Date: 09/17/2024

Re: **Framing Items**
Location: Lot 108 Blakes Pond (113 Frost Meadow Ln. Lillington, NC)
JDS Project No.: RDU2409490
Date of Inspection: 09/17/2024

HOUSE NAME: STONEFIELD  
DRAWING TITLE: FRONT & REAR ELEVATIONS

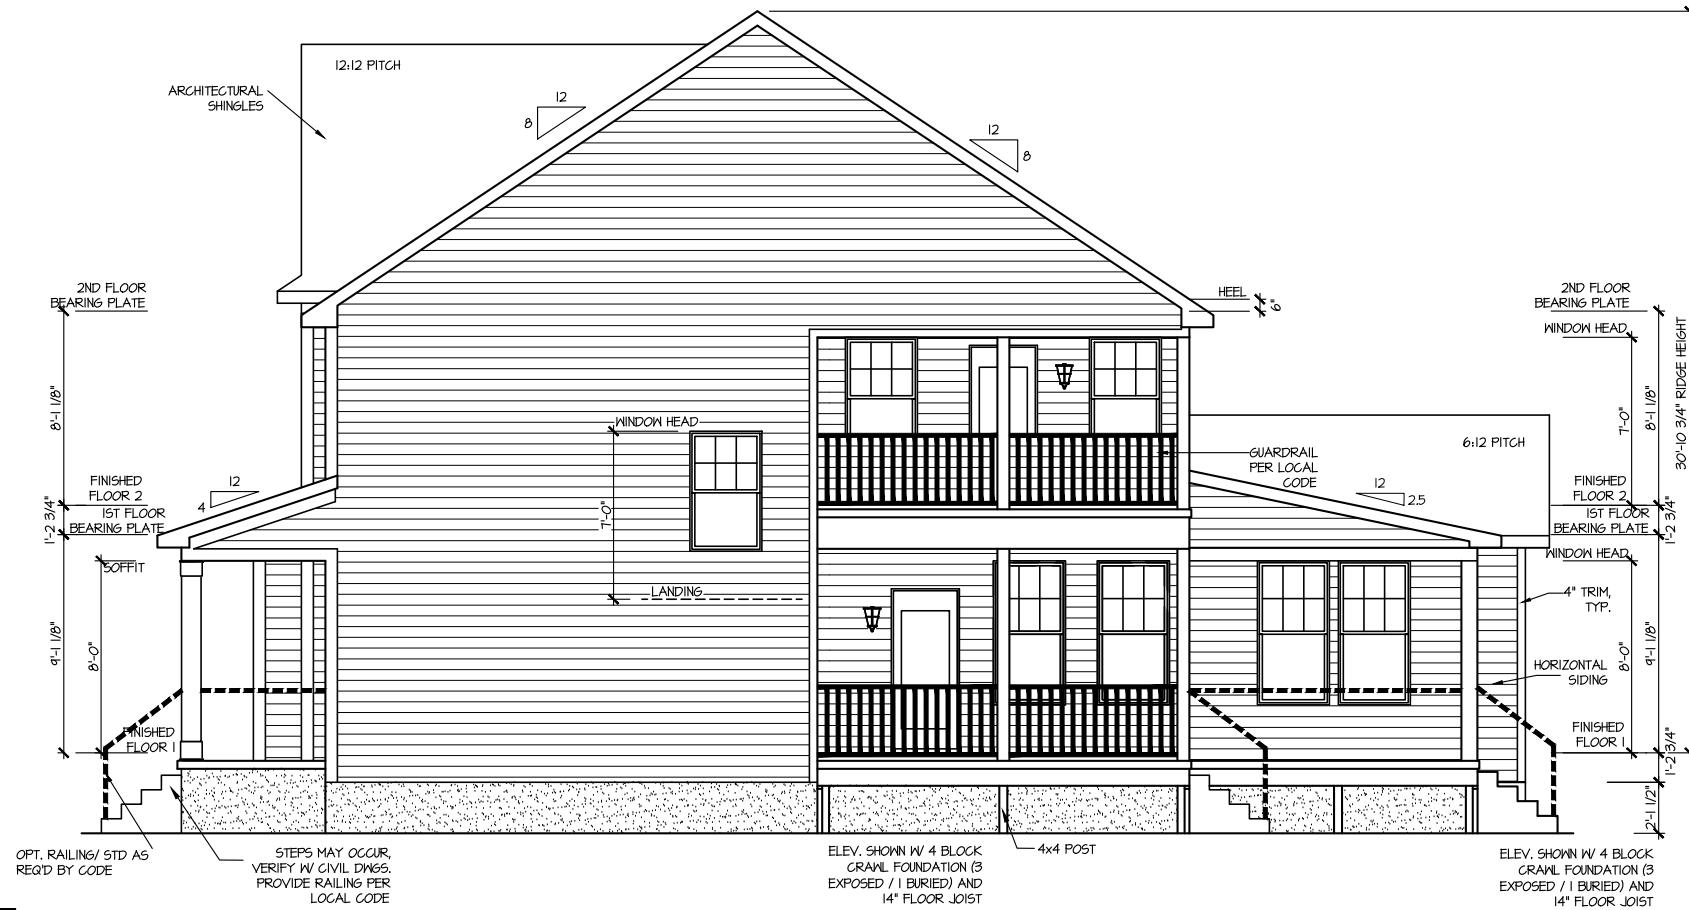
1. The double window to the left of the front door is not framed per plan specifications. The plan specifies (1) jack stud and (1) king stud at both sides of the window. At the center location of the double window only (1) king stud was installed.
2. The inspector commented that the truss layout from the right wall to the double truss at the center of the house is not per plan.

1. Install a 24" CS16 strap from the top of the header down each jack stud on either side of the king stud at the center location.
2. The truss layout is per the manufacturer's specifications, no repairs are required.
